Our ref: P22-672 Noke Solar Farm - planning response

Re: Response to Consultee responses – Land North of Manor Farm, Noke – Planning application ref: 22/01682/F

Designated Ecology Enhancement Area
(Please refer to Ecology Management Plan prepared by BSG Ecology)

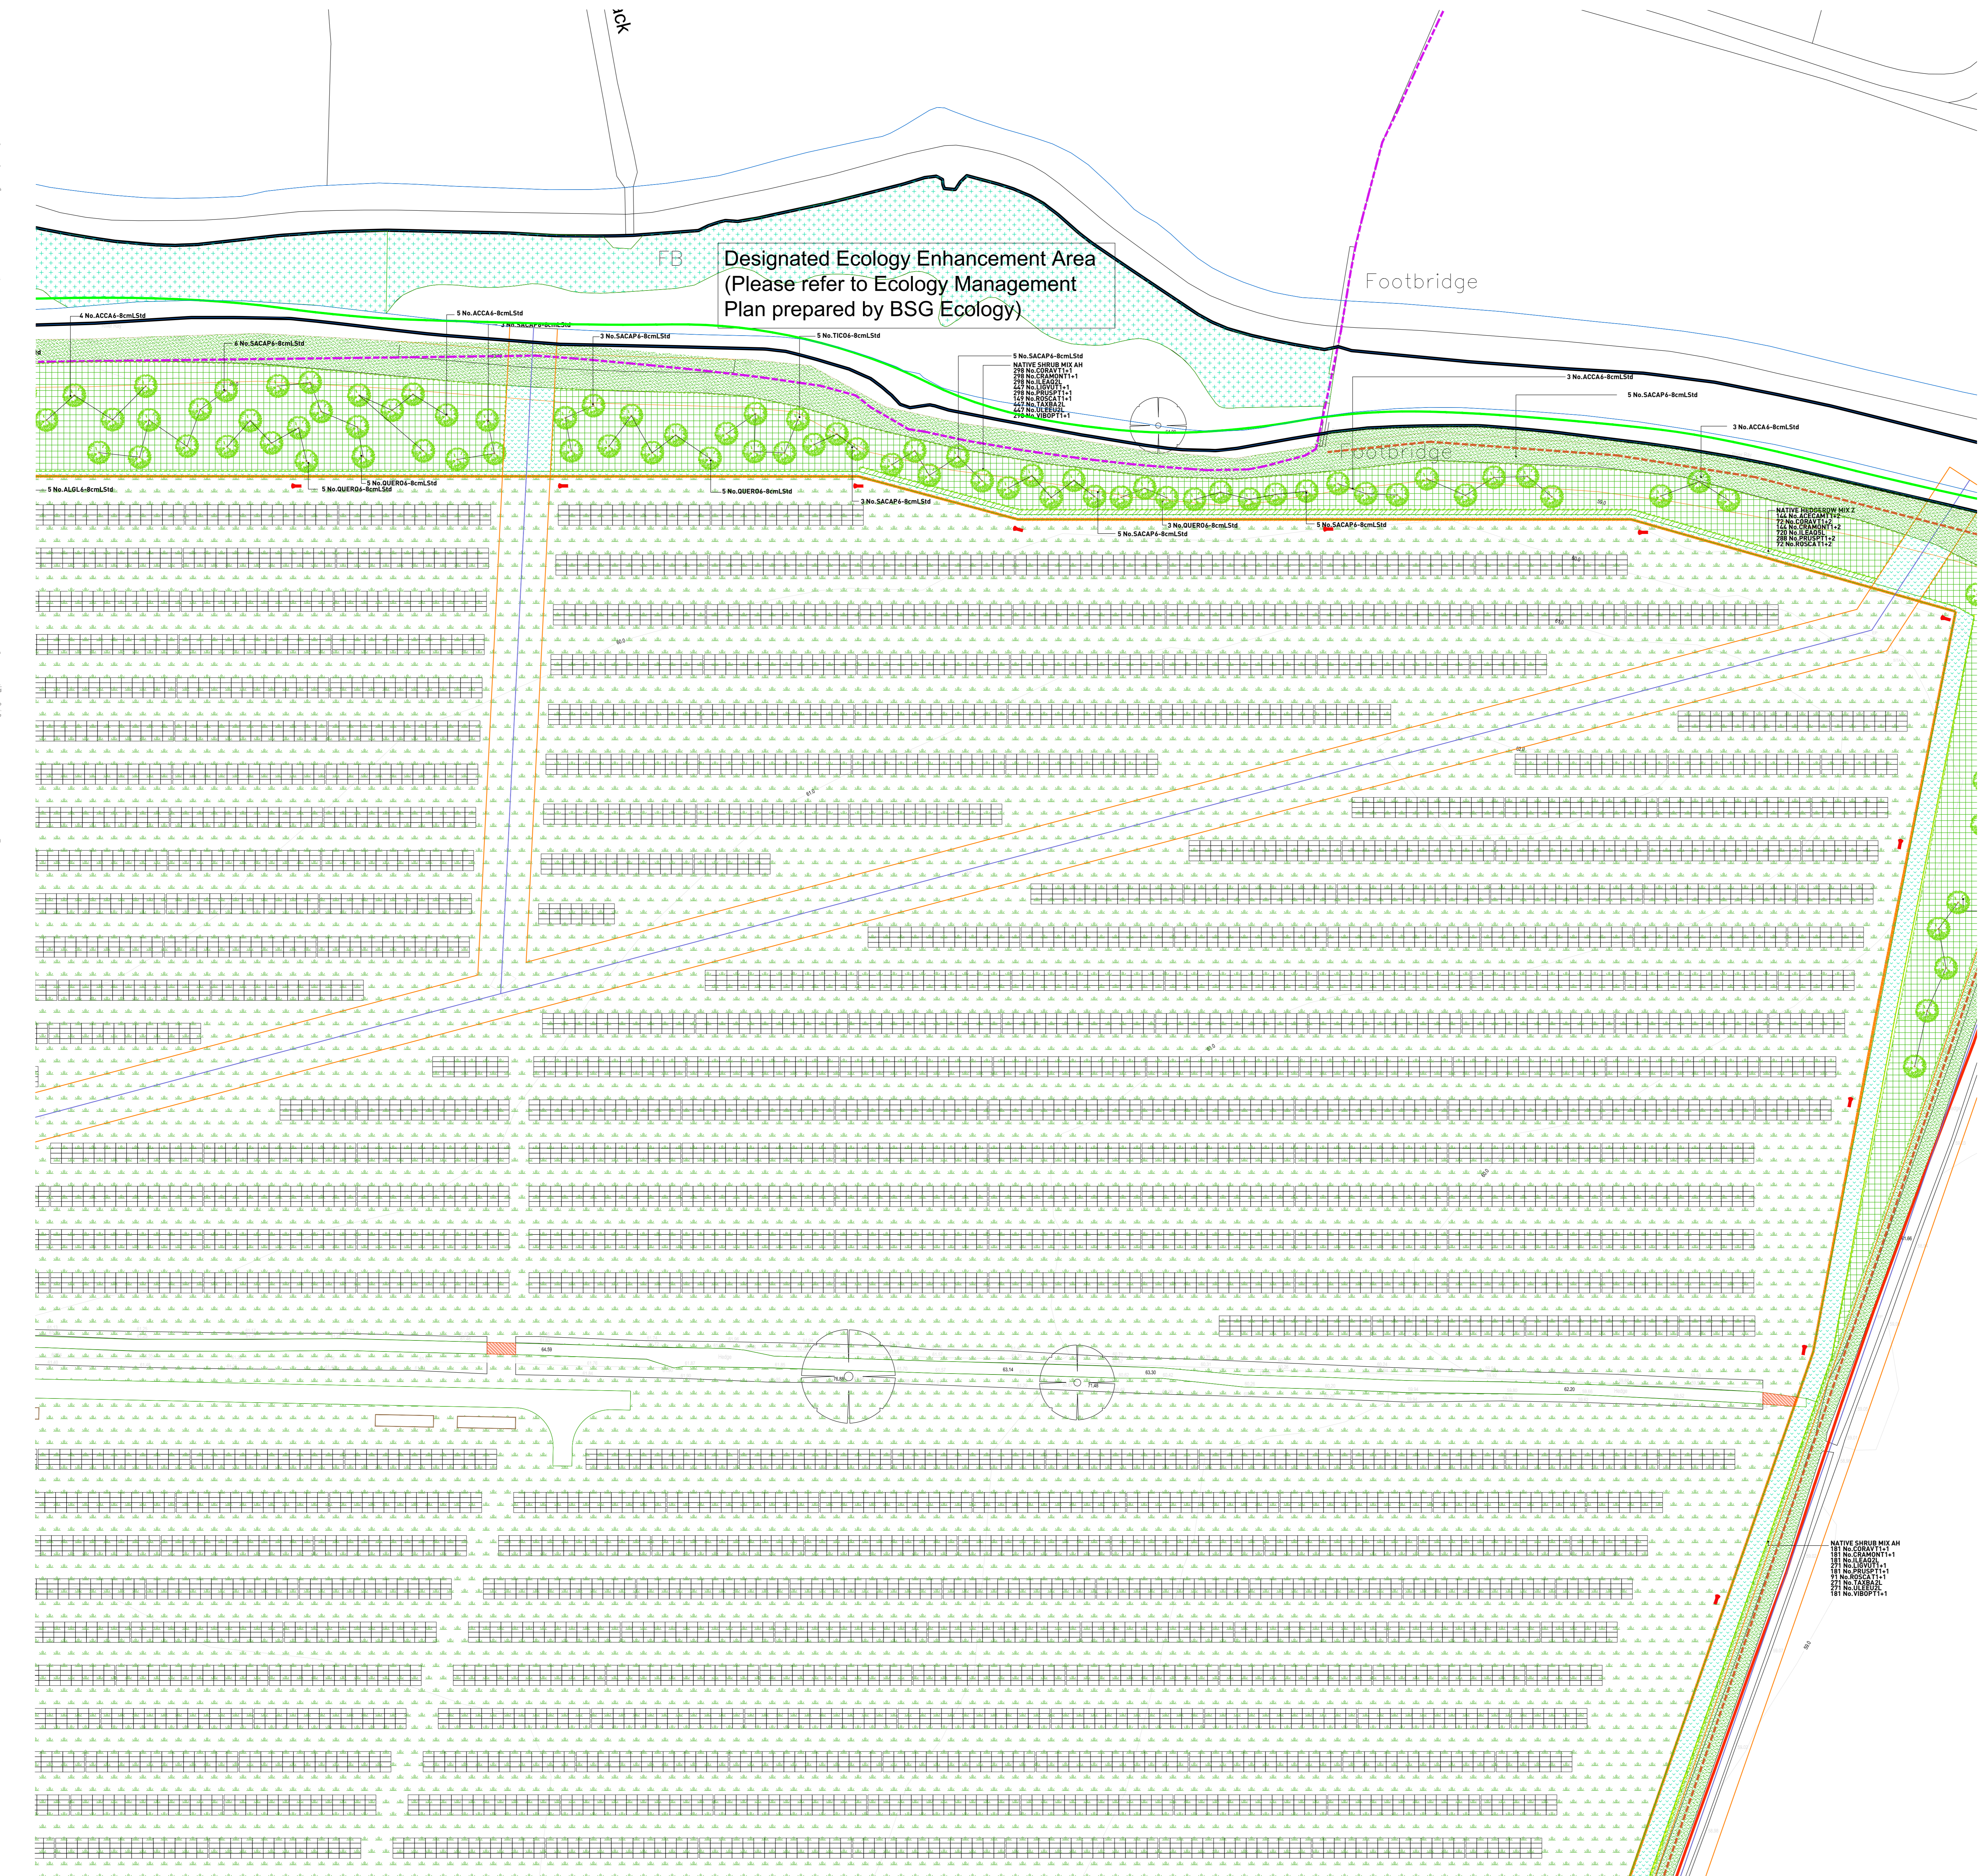
Topic: Habitat; Issue: Sown grassland mix	BBOWT	species mix for the main area of grassland so that it provides species-rich wildflower habitat, with the grazing by sheep being managed to maximise wildlife outcomes
	CDC	a more species rich grassland should be used to maximise ecological benefit on site
	RSPB	grassland around the solar panels managed as species rich grassland with conservation grazing
	Applicant Response by BSG Ecology	As set out above, in order to ensure a significant net gain, and in order to uplift the value of the proposed development further, a revision will be made to the proposed grassland creation within the array areas. This proposal will be to seed the areas with a wildflower rich grass seed mix, such as Emorsgate EM4 specific for clay soils. This would then be managed with grazing at a lower intensity than initially envisaged and in line with Natural England’s grassland management recommendations (Natural England, 2007). The revised habitat and condition will therefore be Modified grassland in Moderate condition, likely to deliver an overall net gain for habitats of 68%.

Applicant Response by BSG Ecology	The solar array area is to be seeded with EM 4 to increase the diversity from the previous proposals. This area will however be regularly inundated and enriched by nearby waterbodies, therefore a high diversity of wildflower and forbs will be difficult to achieve.
Topic: Mitigation; Issue: management of habitats	BBOWT	ecological management plan includes hedgerow management.
	Applicant Response by BSG Ecology	The Applicant will submit a LEMP or similar document setting out detailed management and habitat creation measures.
